Recommendation Report for Planning Permission for Works or Extension to a Dwelling

REF NO: FG/165/14/HH

LOCATION: 29 The Poplars
Ferring

PROPOSAL: Single storey detached garage (resubmission following FG/132/13/).

Proposed floor & roof
plans & elevations

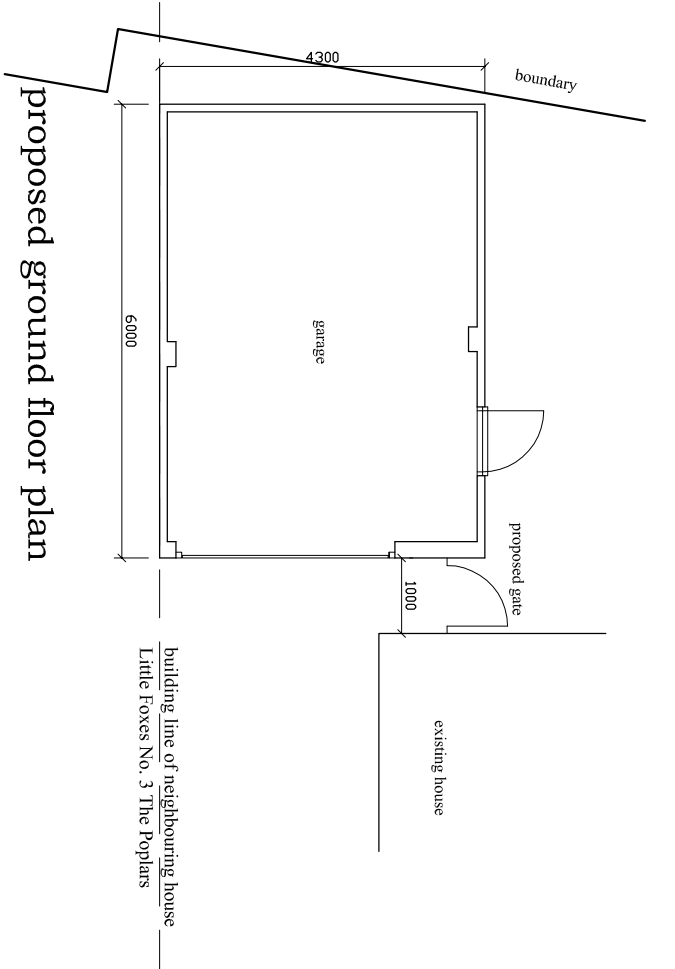
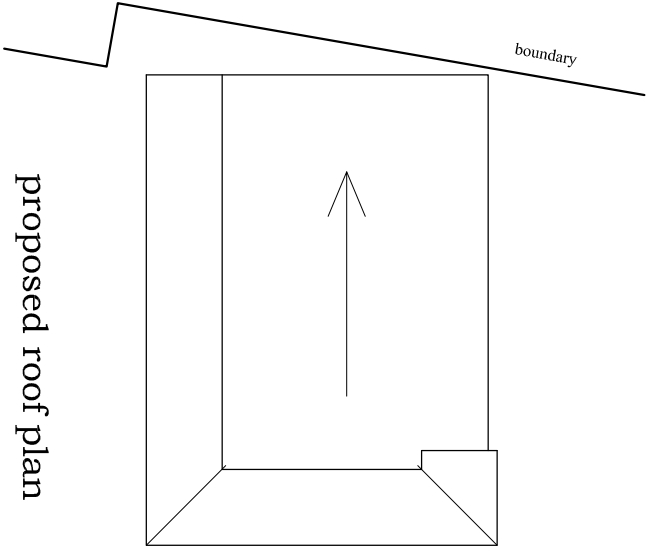
The proposal is for detached brick built garage with a hipped tiled roof to be situated to the east of the property as before. It differs from previously refused application FG/132/13 by being approximately 4m less in length and approximately 1.2m less in width at broadly the same height. It also differs by now having brickwork elevations compared to previous painted render. It has also changed in its orientation and having a greater set-back distance from the road of approximately 6m compared to the previous 2m.

The proposed detached garage is situated to the side (east) of the property and will project forward of the property by approximately 2.5m. There are a number of factors that mean that this level of projection forward of the front of the property is still unacceptable in visual terms. It is considered that the detached garage will still significantly project from the property such that it would adversely detract from the property. The strict front building line observed along the row of bungalows opposite will stand in unacceptable contrast to the staggered arrangement being proposed where the garage will be presented and read first in the street scene and the property second. This effect will be amplified by the narrow road and the fact that it forms a cul-de-sac and the proposed garage will be positioned at its end with harmful views being presented at some distance along the straight road.

It is considered that the proposed level of projection of the garage forward of the property which has a straight building line would still harmfully erode the strict building lines that characterise the area, as identified at appeal. The reduction in size of the garage compared to the previous application is not considered to overcome this serious and unacceptable effect.

It is therefore considered that the detached garage is still unacceptably harmful in design and visual terms and has failed to overcome concerns raised at appeal. It therefore conflicts with policy GEN7(ii) of the Arun District Local Plan.
